Subject: FW: [EXTERNAL] Re: Planning Application Incomplete - 24/00536/DOM  
Attachments: Brackle 001.pdf; Brackle-002B.pdf; Brackle 003.pdf

From: Steve Tubb [REDACTED]  
Sent: 14 March 2024 12:37  
To: dcplanning <[dcplanning@chichester.gov.uk](mailto:dcplanning@chichester.gov.uk)>  
Subject: [EXTERNAL] Re: Planning Application Incomplete - 24/00536/DOM

| 001 | |

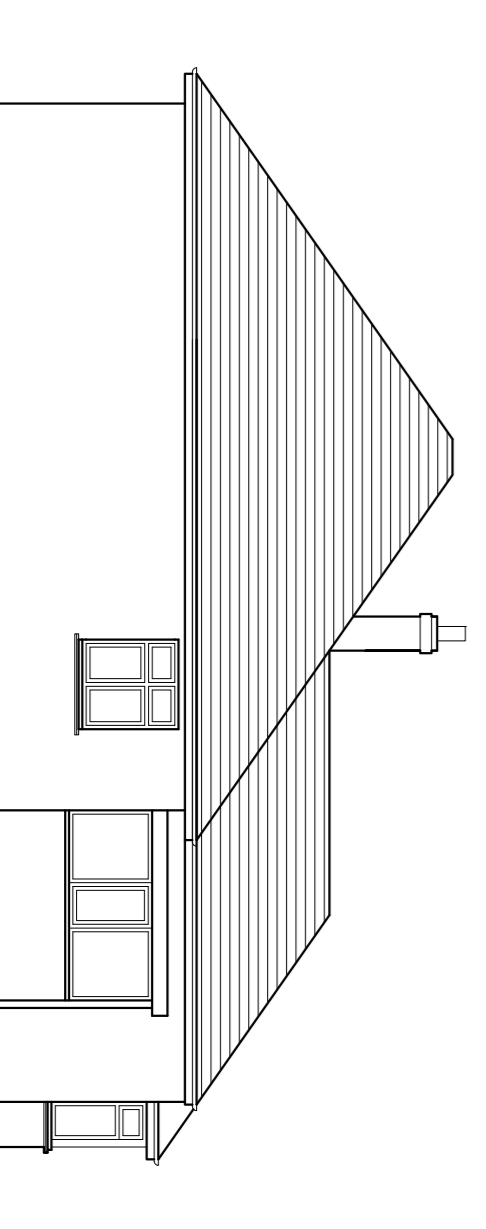
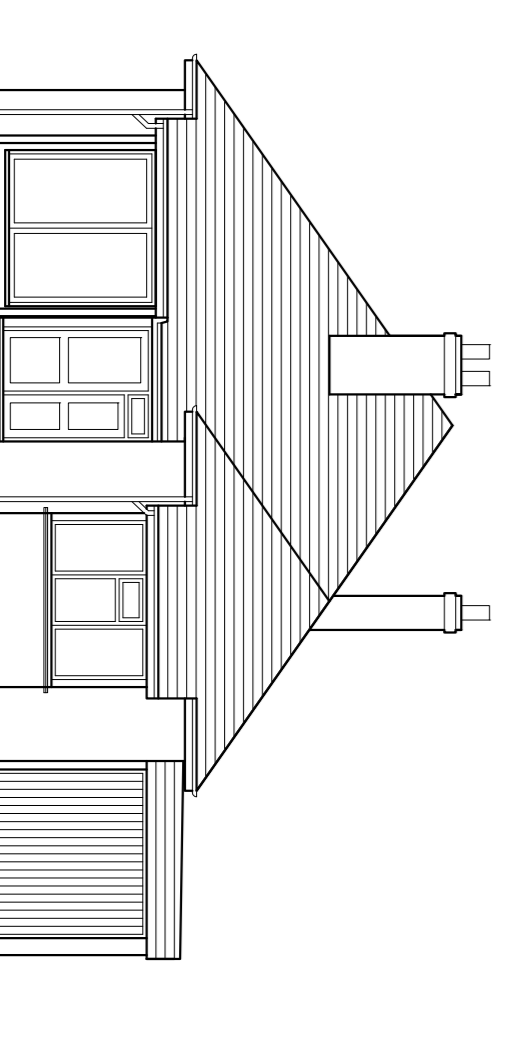
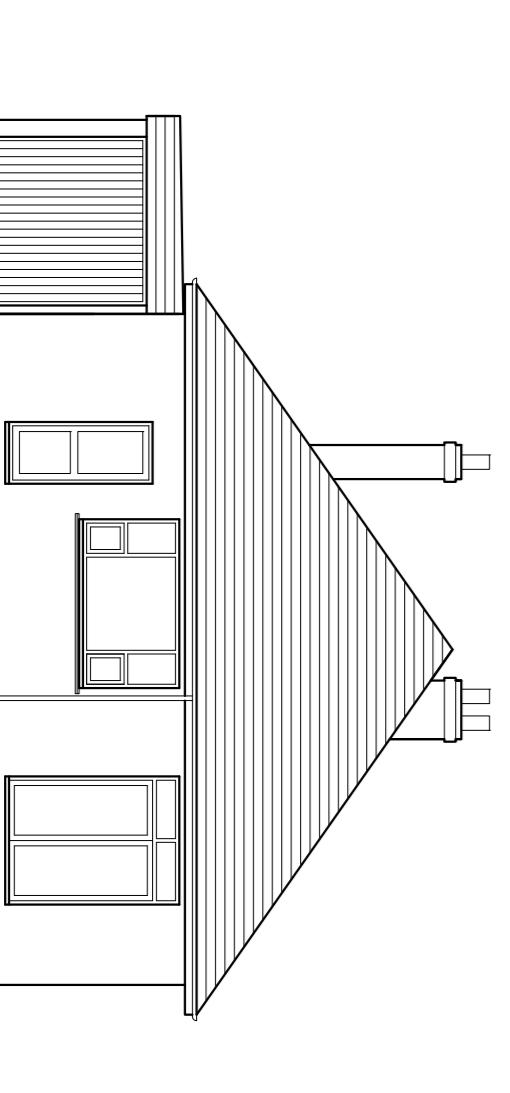
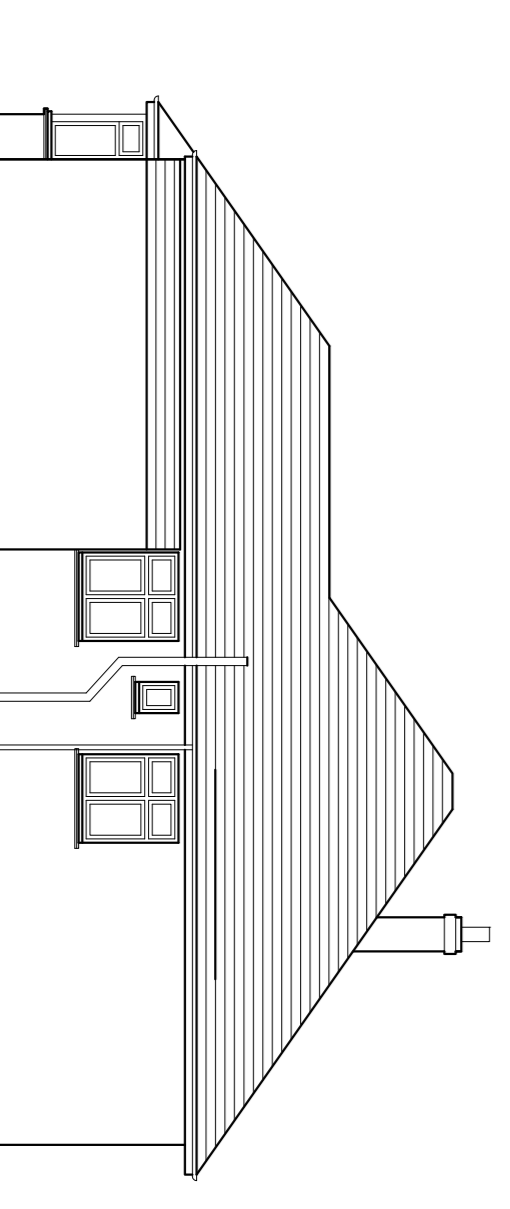
1) Please review and amend the existing and proposed floor plans by appending associated north points to show the orientation of the building.

Drawing revised and attached.

DRAWING TITLE  
Proposed Extension and Alterations  
Existing and Proposed Roof Plans  
Block Plan

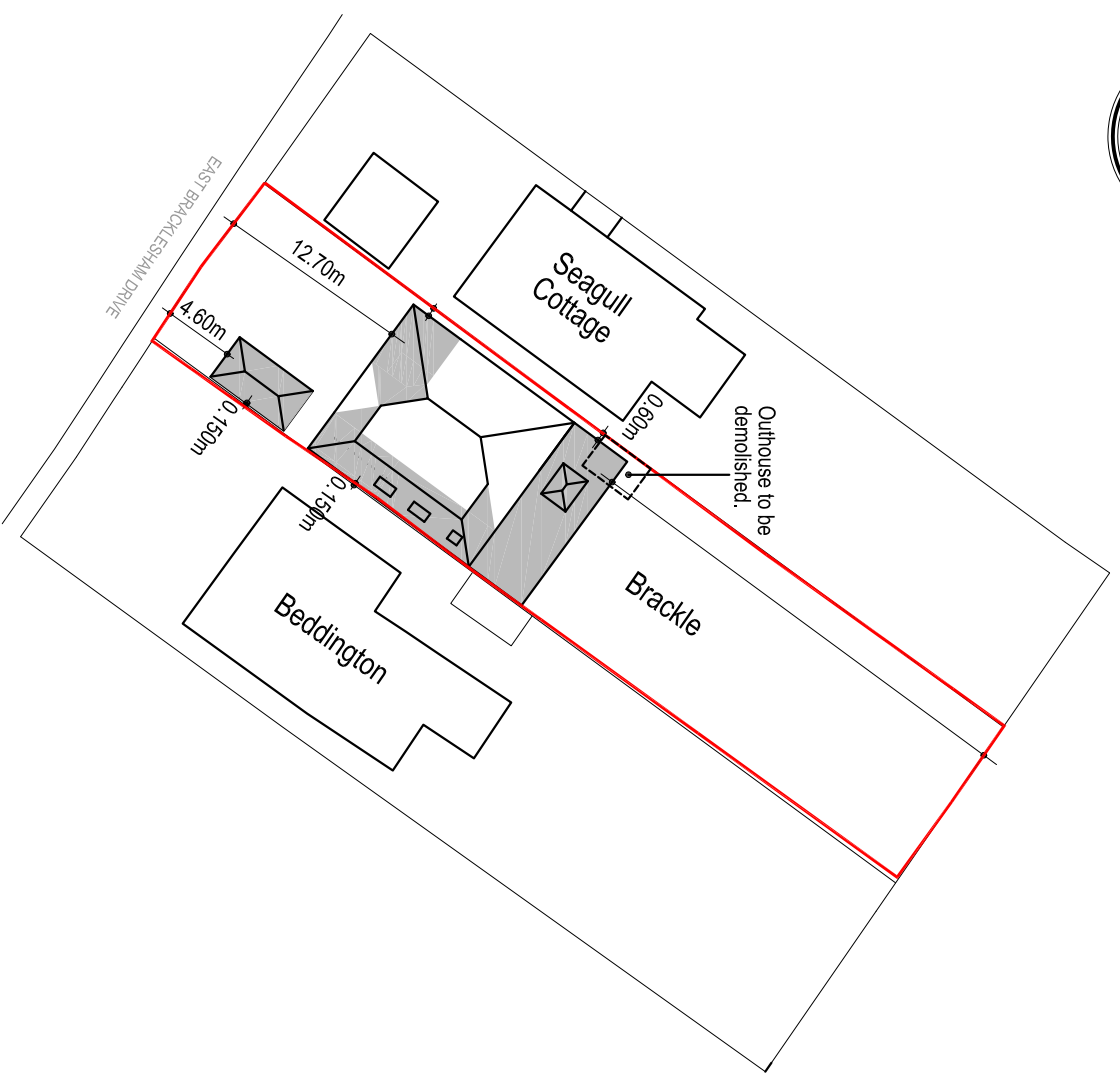
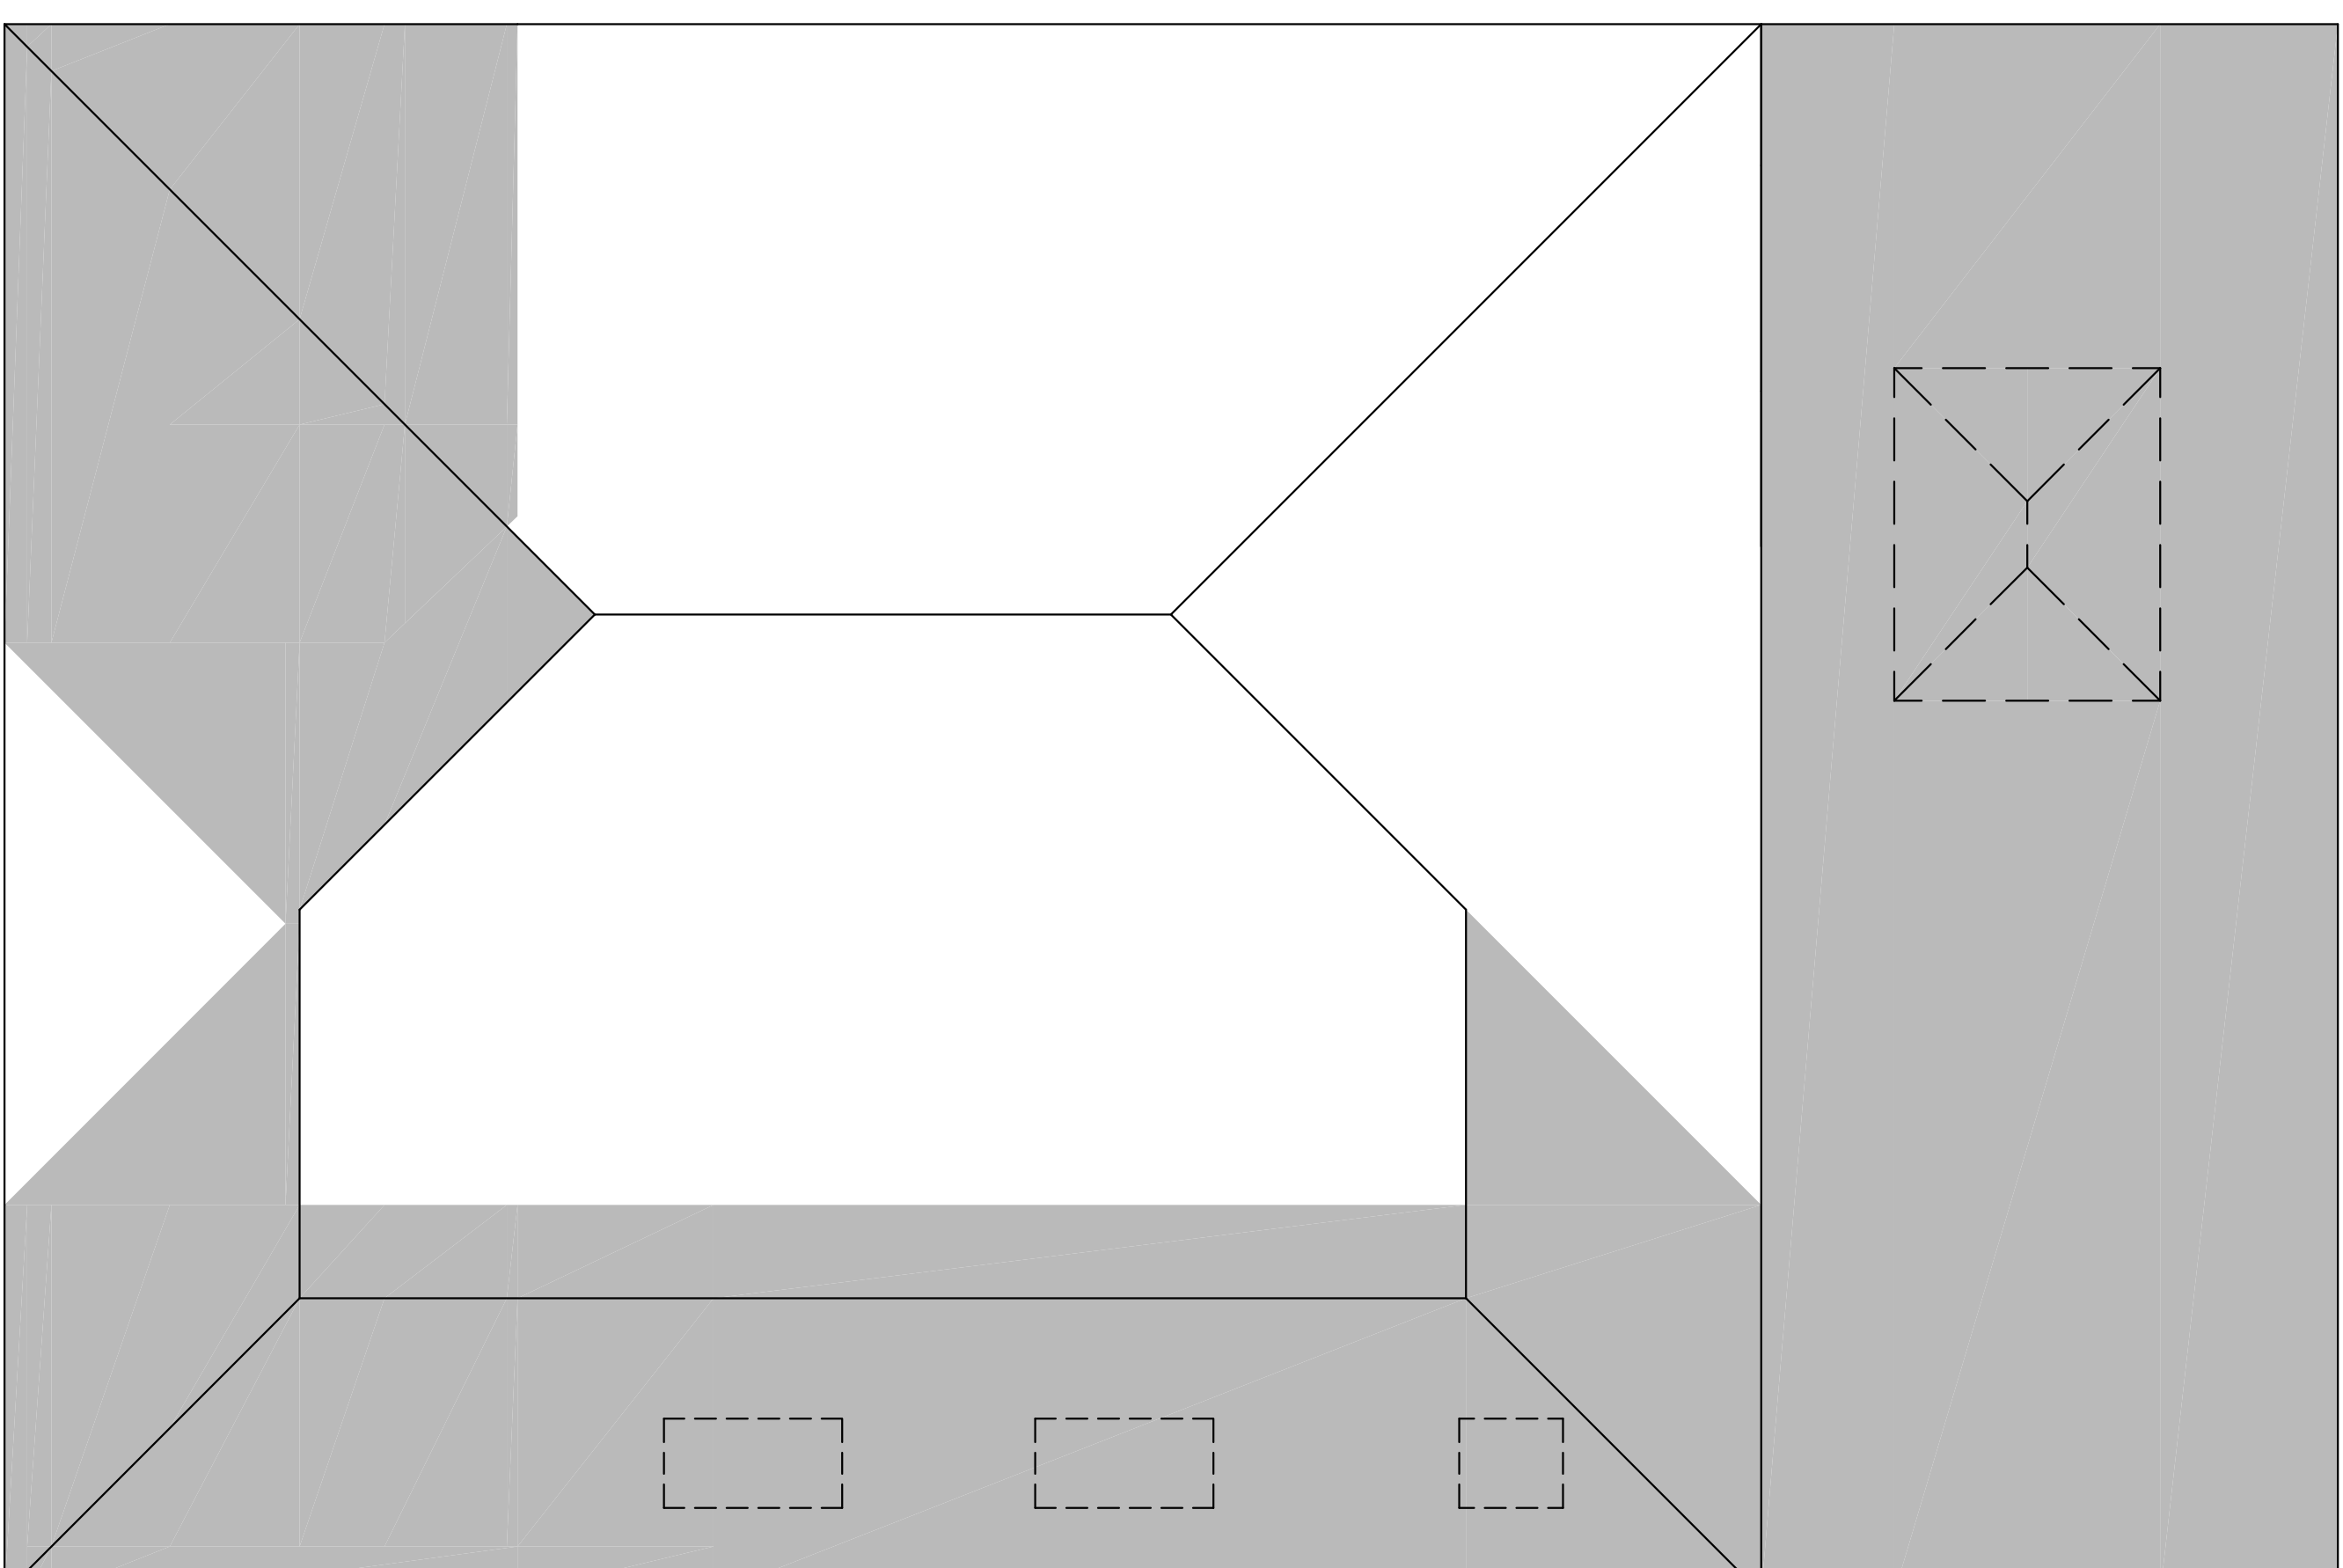
2) Please review and amend the north points detailed on the existing and proposed roof plans, as they do not appear to correspond with the orientation shown on the submitted Location and Block Plans.

Drawing revised and attached.
